WEST SUSSEX COUNTY COUNCIL CONSULTATION

TO:	Arun District Council FAO: Simon Davis
FROM:	WSCC - Highways Authority
DATE:	2 April 2019
LOCATION:	Babsham Business Centre Babsham Lane Bersted PO21 5EL
SUBJECT:	BE/30/19/PL Retention of secure containers, welfare facilities & secure fencing together with associated landscaping works.
DATE OF SITE VISIT:	N/A
RECOMMENDATION:	More Information
S106 CONTRIBUTION TOTAL:	N/A

DRAWING TITLE
SITE LOCATION AND BLOCK PLANS

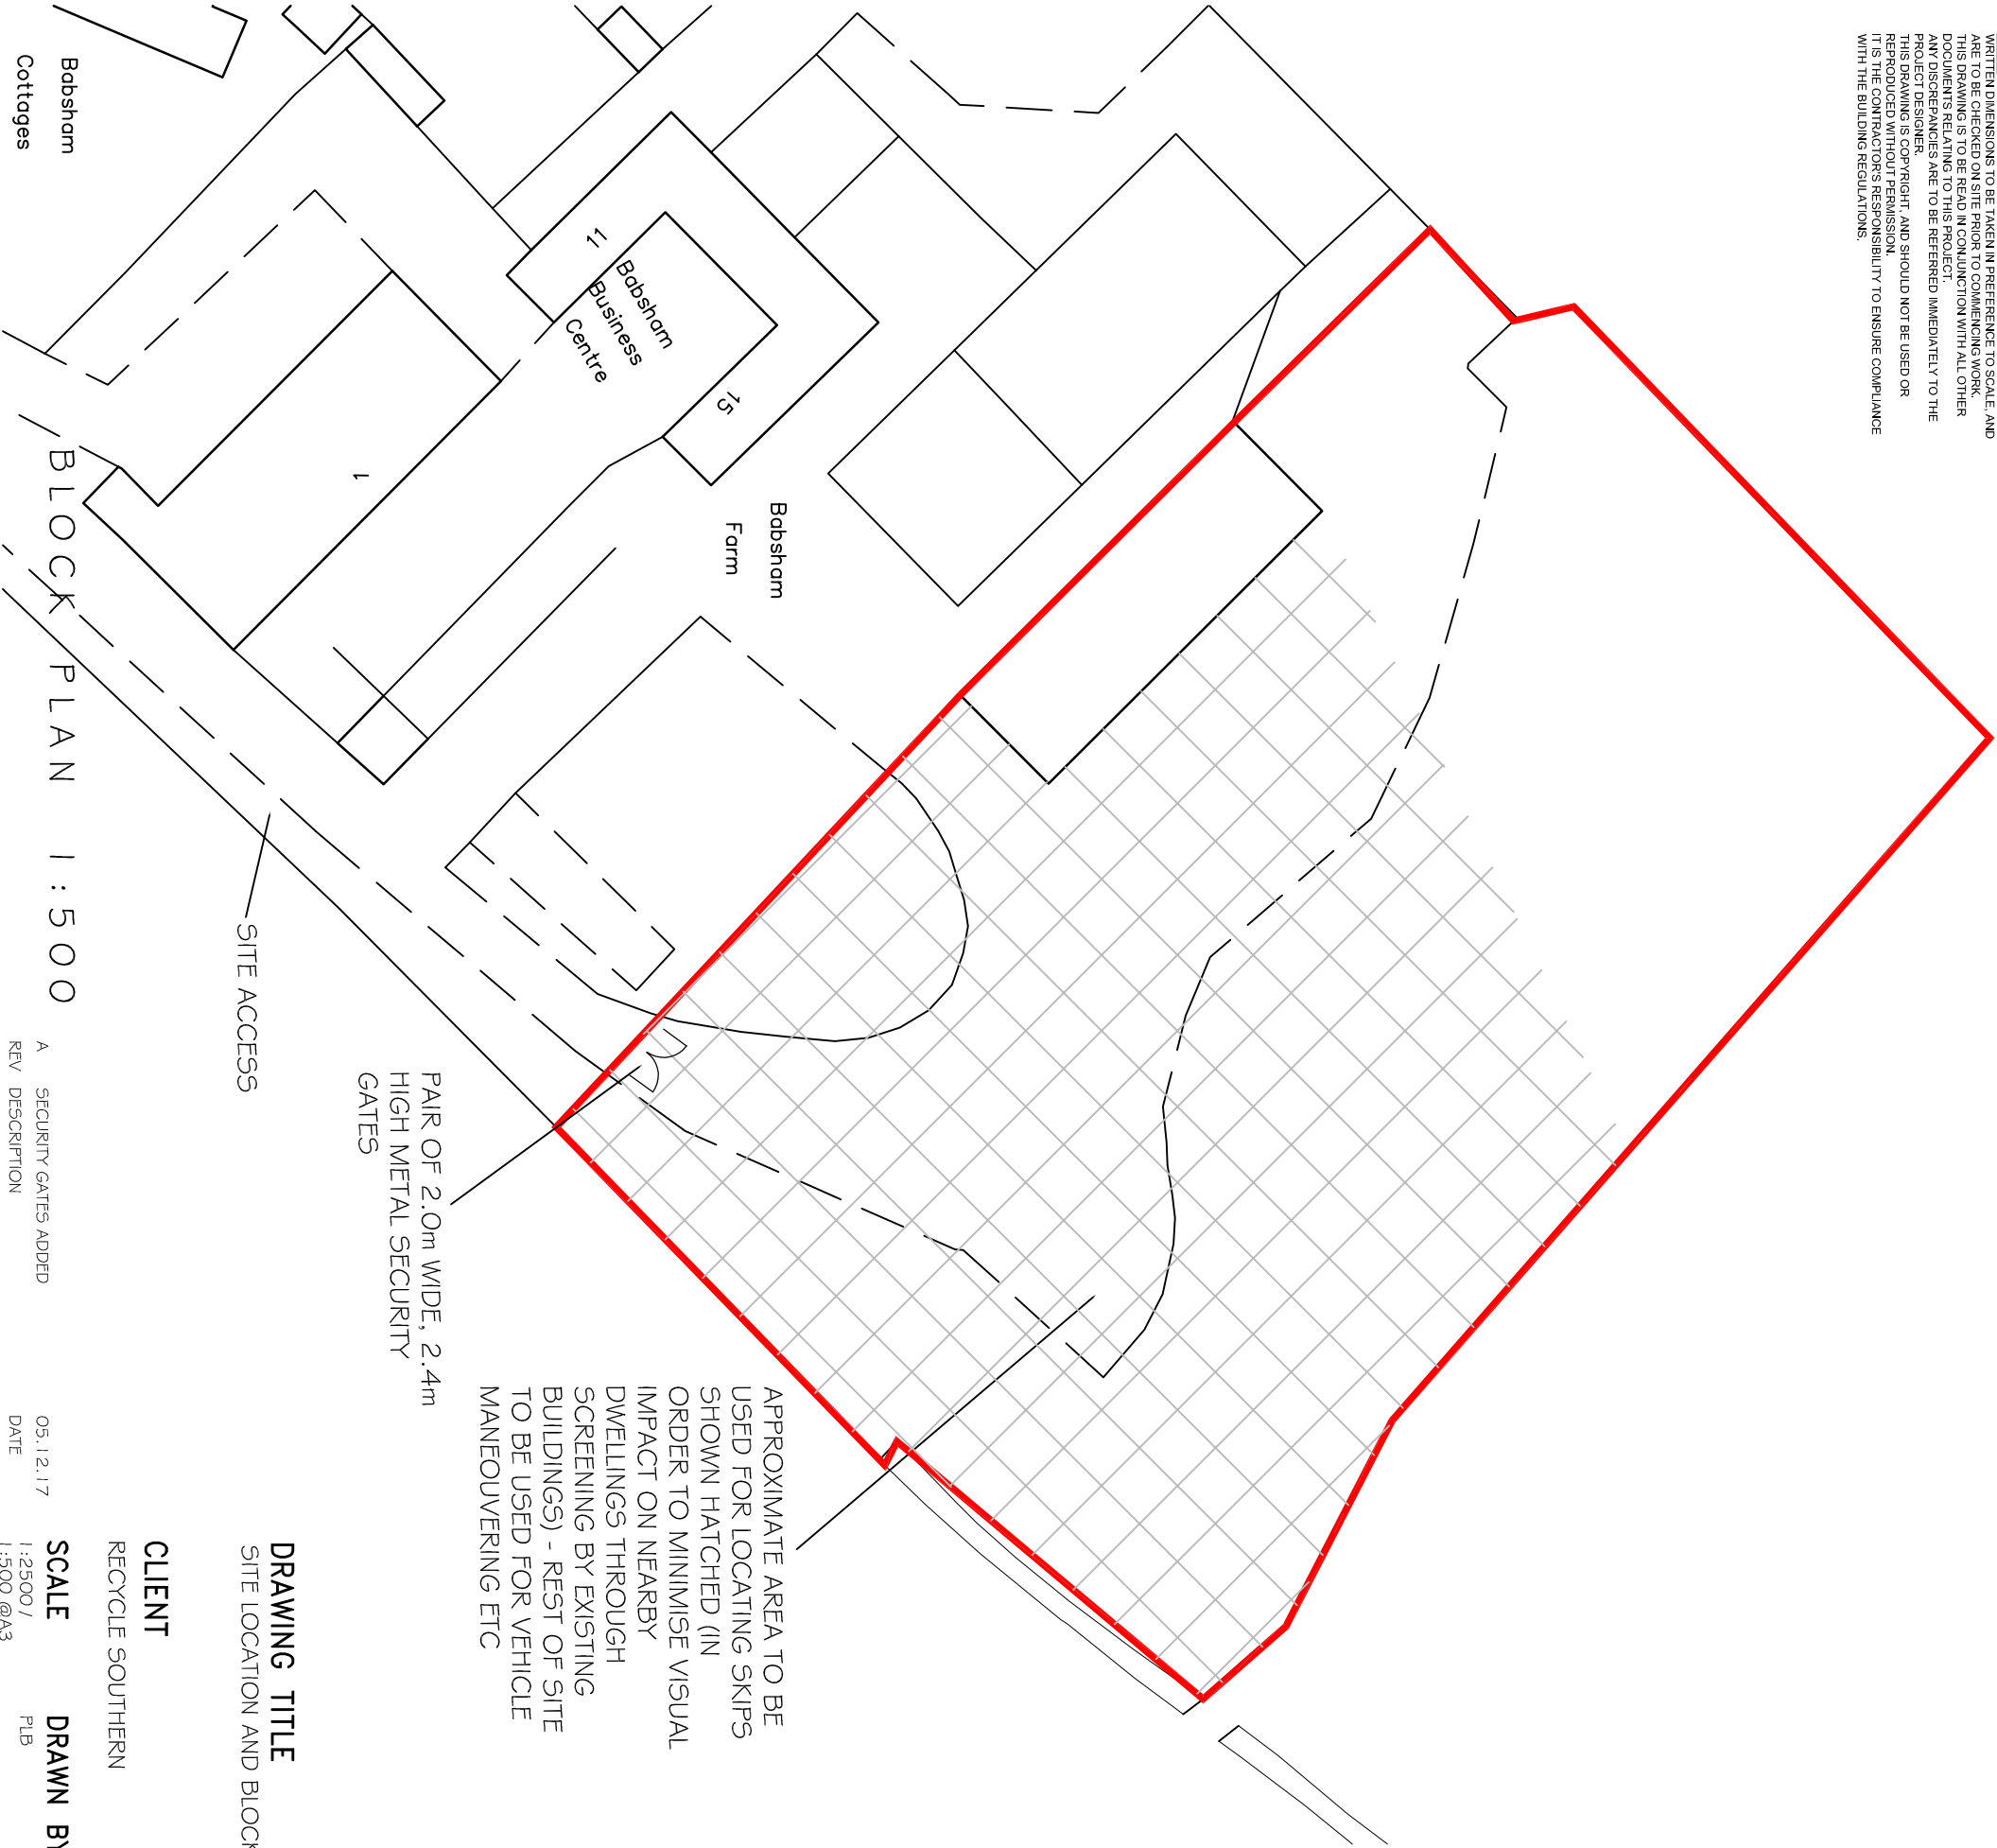
The applicant is also requested to provide a revised plan indicating the location of proposed lorry parking on the site and the number of spaces that will be provided.

point 18 of a previous objection, the LHA acknowledges that this was misread. The applicant clarifies in this email that no staff will be permanently employed on site but will be on site during the delivery, collection, sorting and stacking of skips, and for occasional repair work to skips. The applicant is requested to provide details of existing staffing levels on site and the staffing levels anticipated to be required during the undertaking of the above operations. Will any staff parking be provided on site? If so, this should be demonstrated on a revised plan.
